DECISION DELEGATED TO HEAD OF PLANNING

Application No: H14-0055-26 **Applicant:** Burmor Construction Ltd

Proposal: Details of existing & proposed site levels and proposed floor levels of buildings, hard surfaced areas and garden/amenity areas (Condition 11 of H14-0117-22)

Location: Land East Of Surfleet Road Pinchbeck Spalding

Drawn By:	AD	Client:	Burnor Construction
Chkd By:	LC	Project:	Land East of Surfleet Road Pinchbeck
Scale @ AD:	1:350	Title:	External Levels Layout
Date:	February 2023		
Status:	CONSTRUCTION		
Project No.:	26043	Drawing No:	109
		Rev:	G

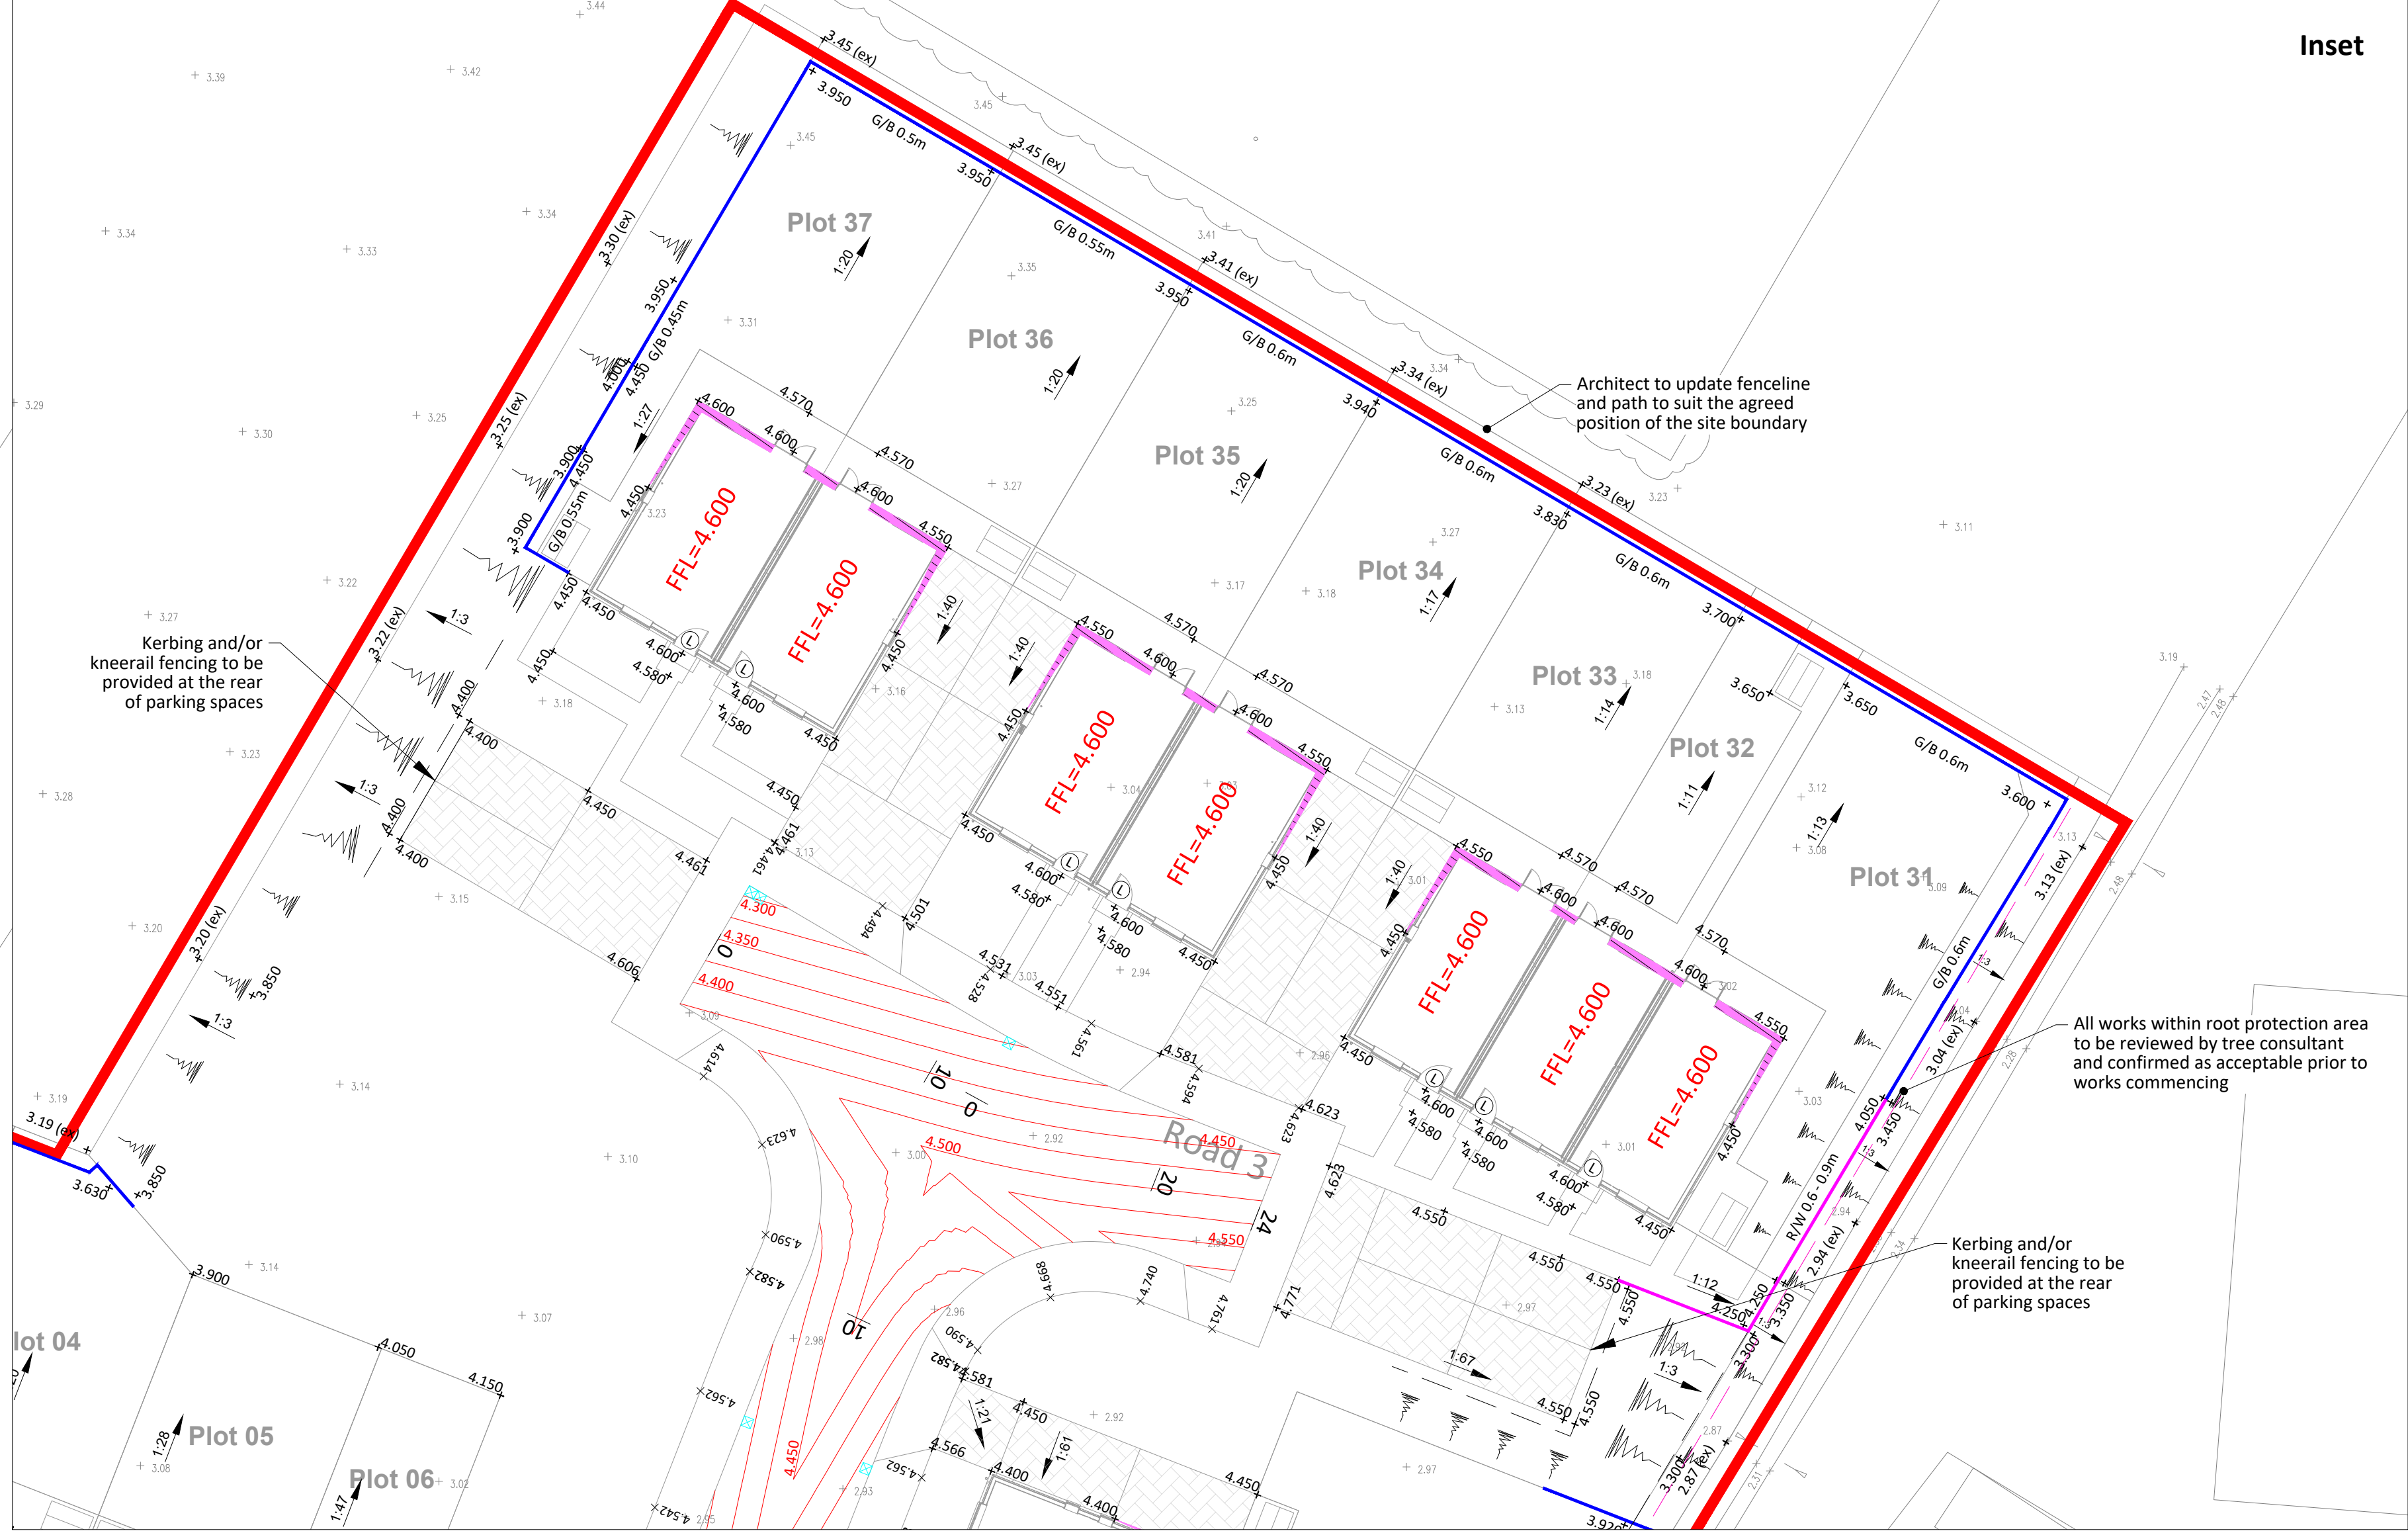
Condition 11 was already discharged under application H14-0368-23; however, the current application has been submitted to update the approved details. Whilst the levels details appear to be acceptable, the layout shown within the submitted plans is not consistent with the approved layout. For example, the roadway near plot 37 has been altered. This has been raised with the applicant's agent and they have been advised to submit an amendment application to apply to

update the submitted layout.

Condition 11 cannot be discharged again based on the submitted details as an unapproved layout is shown.

The submitted details conflict with the approved layout plans and as such, condition 11 cannot be discharged.
